Re: Submission to AMENDED State Significant Development No. SSD 16-7684

Site: 241-249 Wheat Road, Cockle Bay

Proposal / Proposed Development: Stage 1 Concept ('Built Form Envelope')

Submission on behalf of: Tianlong Ribbon Pty Ltd (Future Owners of 'The Ribbon Hotel' at 31 Wheat Road)

**STAGE 1 SSSA AMENDED
CONCEPT PROPOSAL SK-4.01**

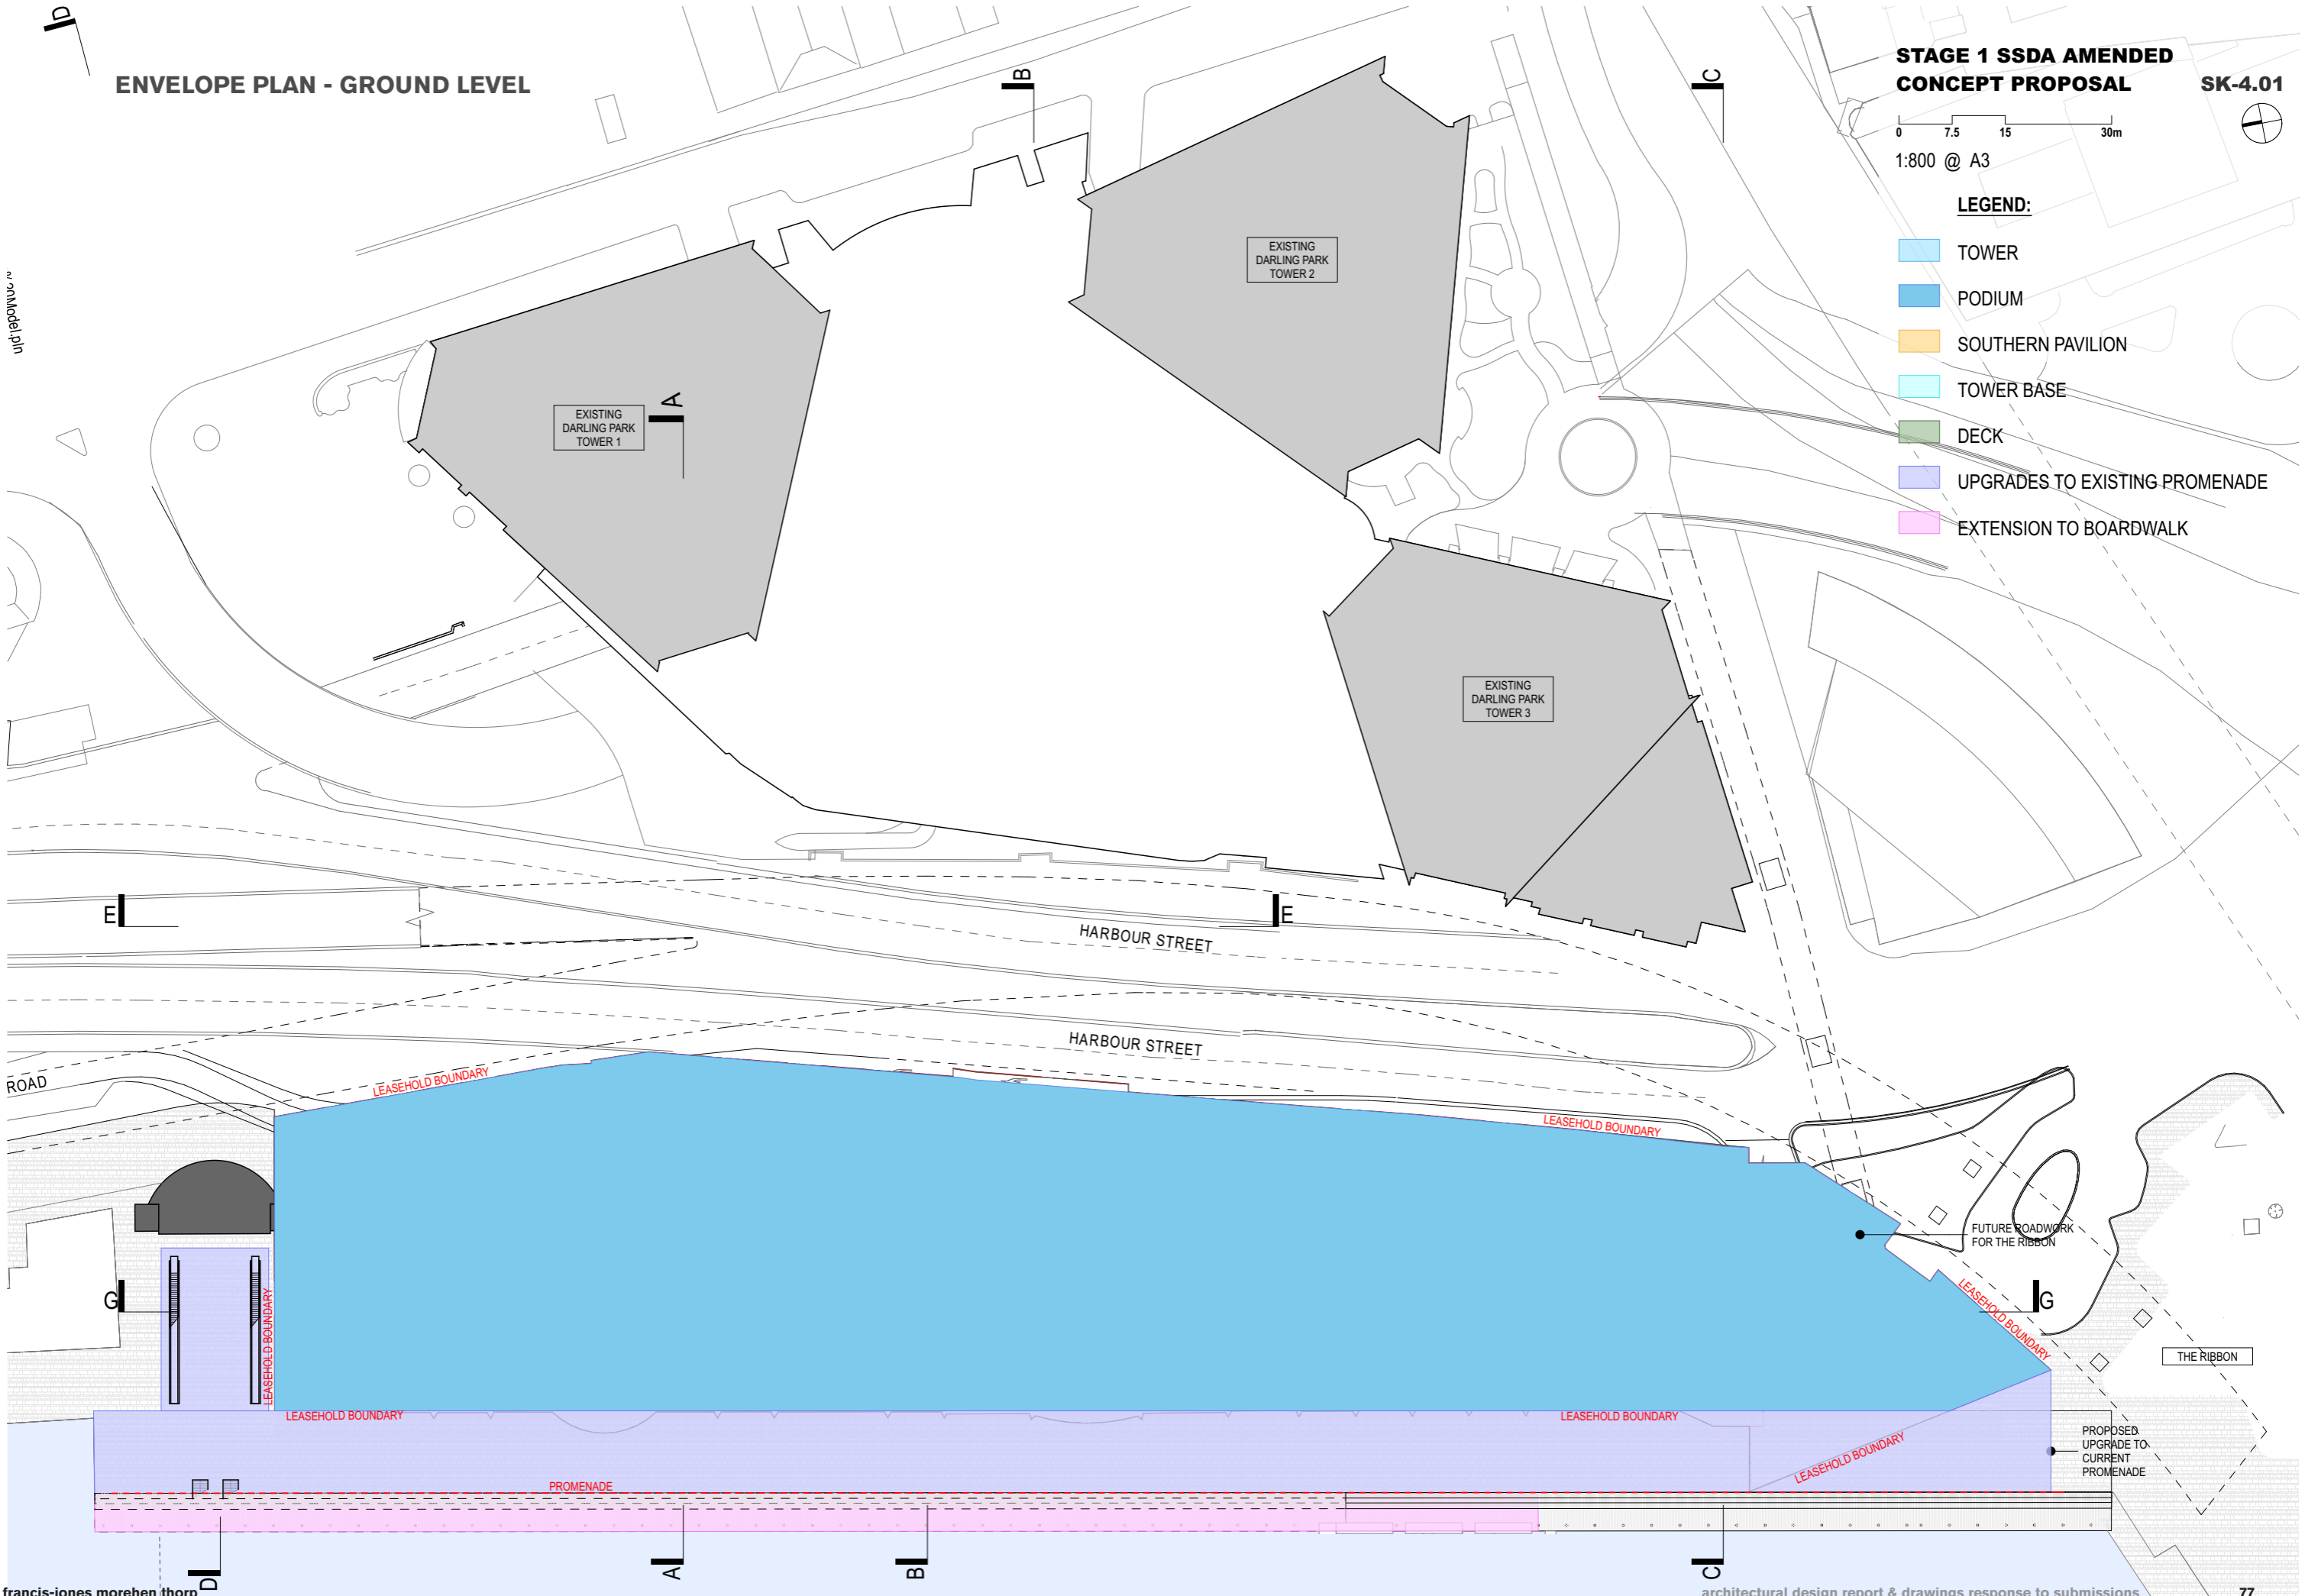
- 2.7. **Podium Length & Setback from Waterfront:** The Proponent claims that the podium is reduced from 209 to 144m. However, the envelope at the southern end (ground level) still extends to the southern end of the lease boundary. We suggest that the podium should not extend past the line of the Druiitt Street pedestrian bridge and stairway to the waterfront as shown in the indicative designs.

- 3.1. Push the Primary Tower at least another 10-15m north whilst providing good separation to Pymont Bridge and public open space;
- 3.2. Reduce the Primary Tower height to at least RL150 with no additional penetrations for roof articulation above that height;
- 3.3. Reduce the Ground Level Envelope at the southern end to accord with the indicative design shown for the Druiitt Street pedestrian bridge/waterfront access i.e. not permit it to extend to the southern boundary of the lease.

ENVELOPE PLAN - TYPICAL TOWER LEVEL

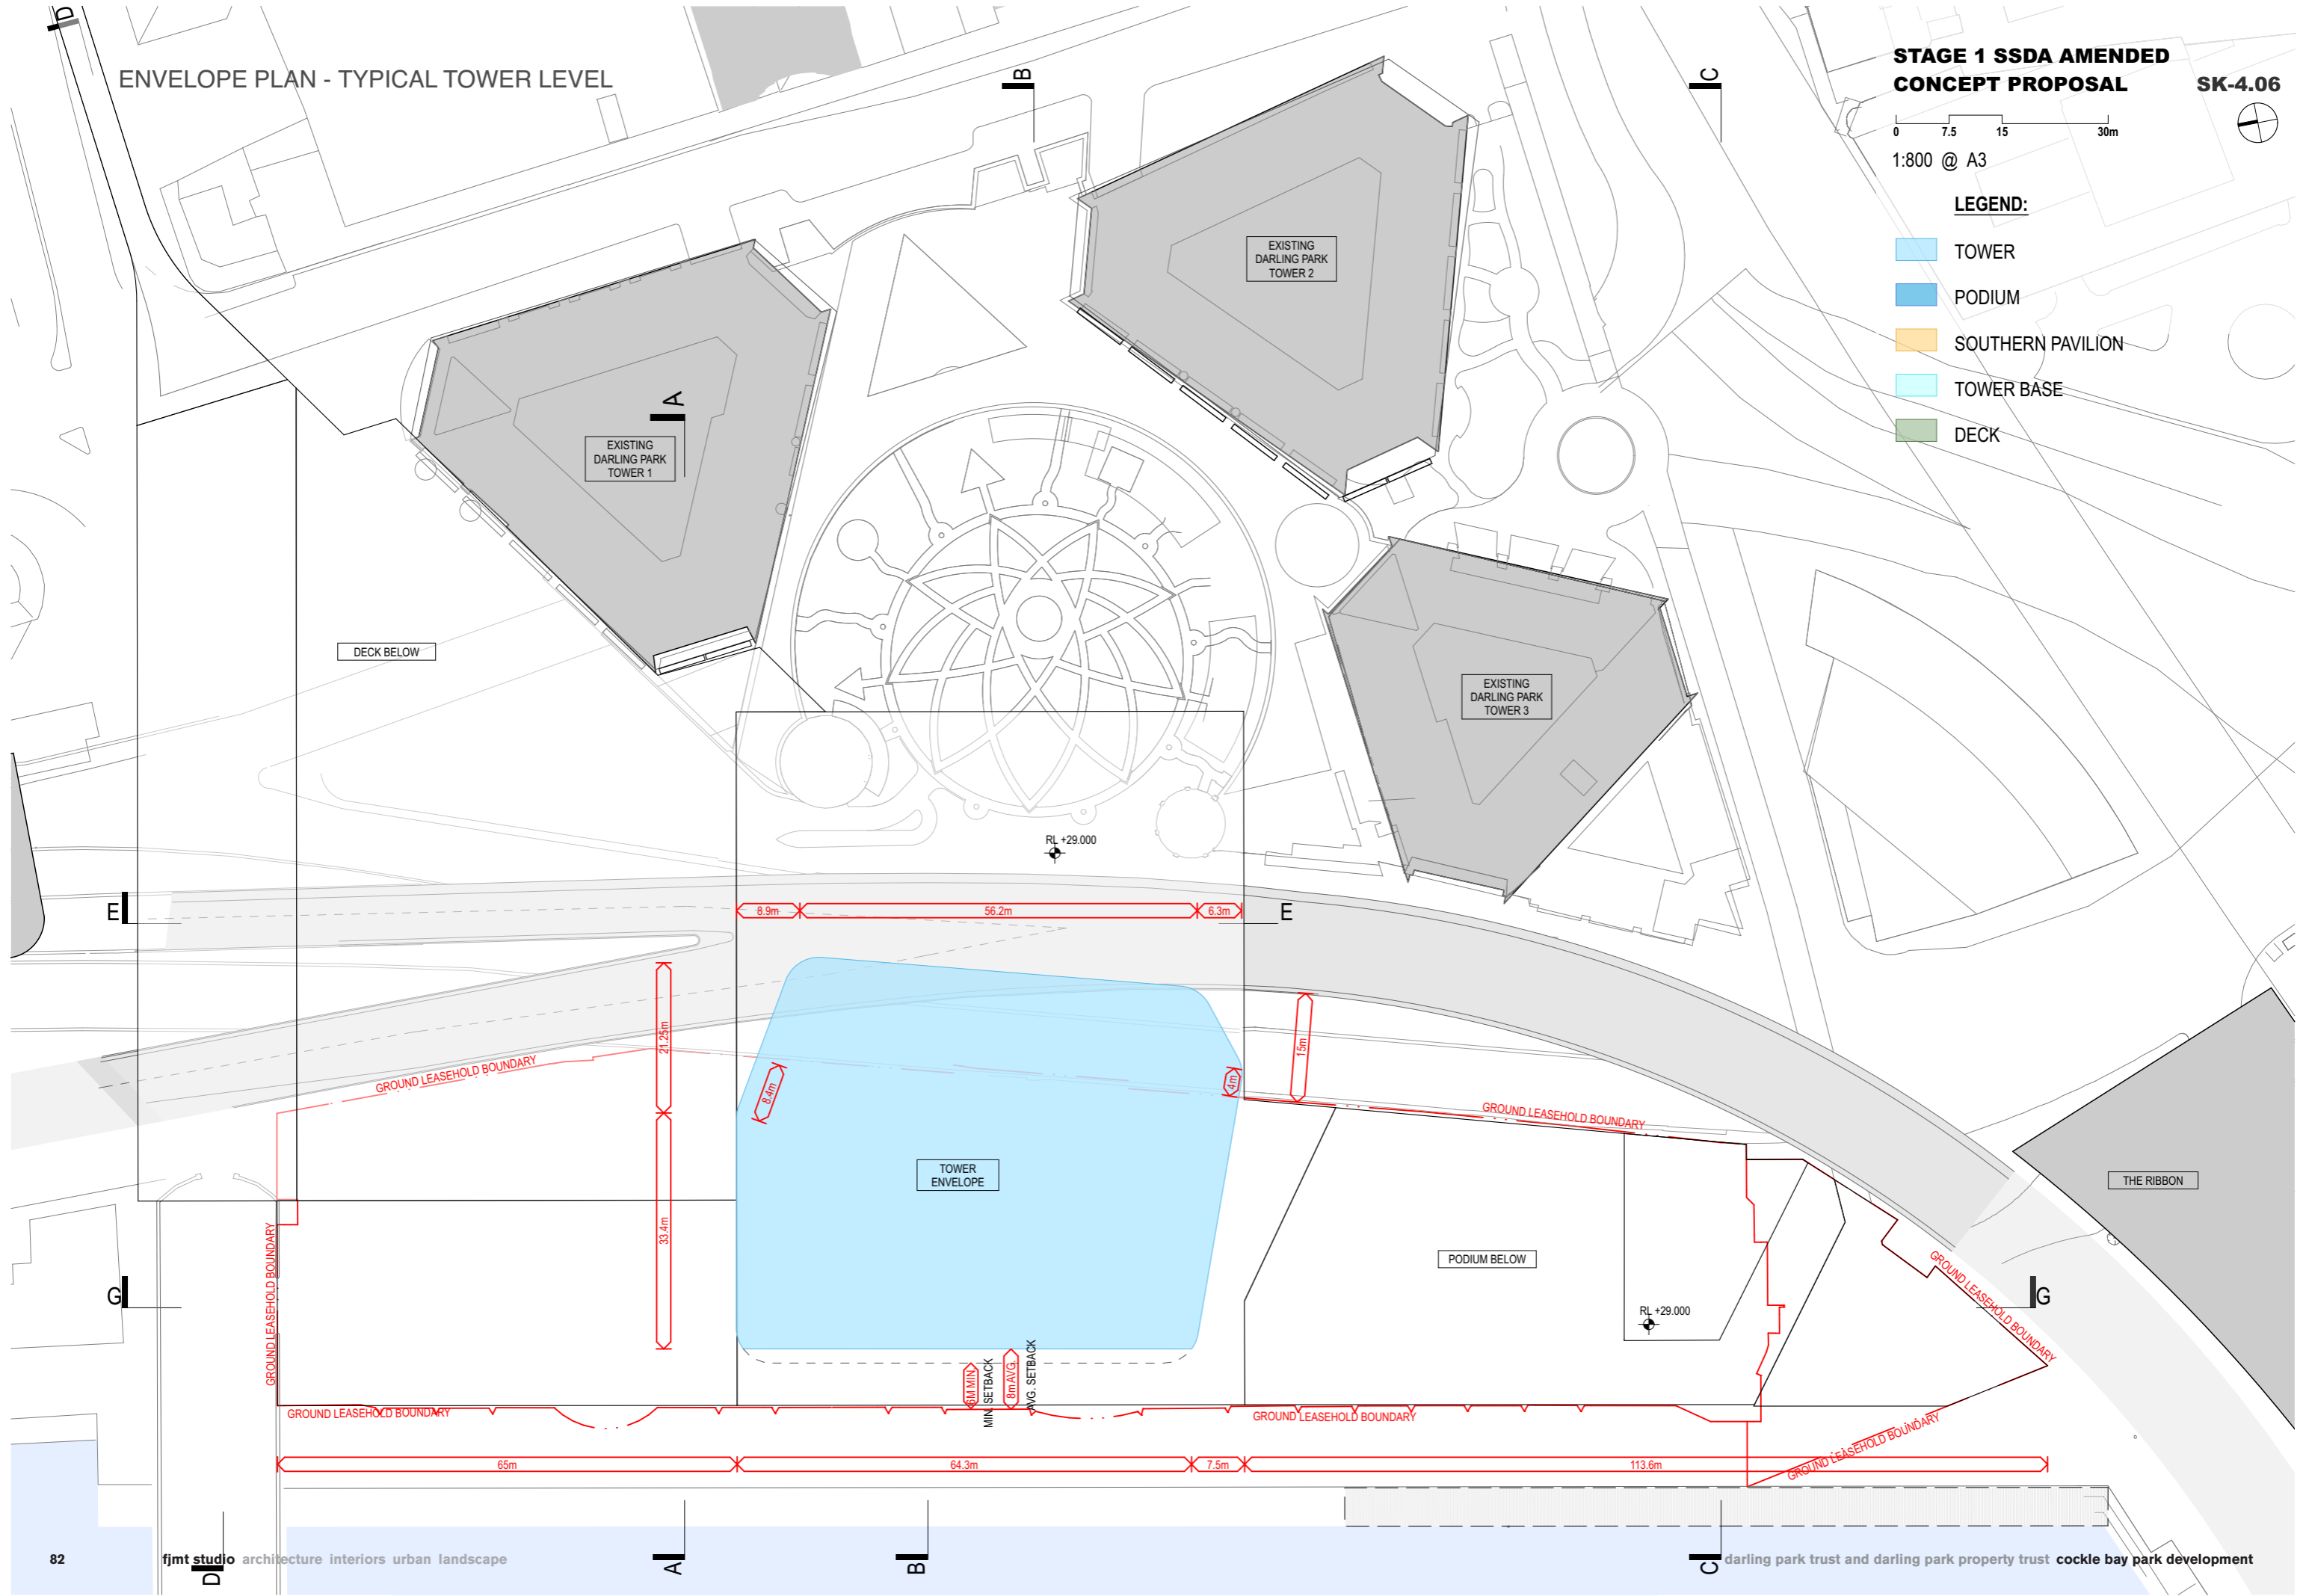
- b) However, as Figure 10 above shows, whilst the bulk of the envelope floorplate has decreased in a north-south direction it is now squarer in shape and instead of narrowing to the south (to reduce the scale/bulk to the south and potentially allow greater penetration of morning sun to the southern waterfront) it is wider and bulkier at the southern edge of the tower.

- c) The setback from the waterfront may have increased the minimum slightly (3m to 6m), but continues to provide an 8m weighted average setback that is insufficient to offset the dominance of the tower over the waterfront. Whilst the site has limitations to how far east the tower can be setback, the proposed height in combination with this minimal setback is not consistent with the desired character, amenity, scale and public importance of the Cockle Bay waterfront.
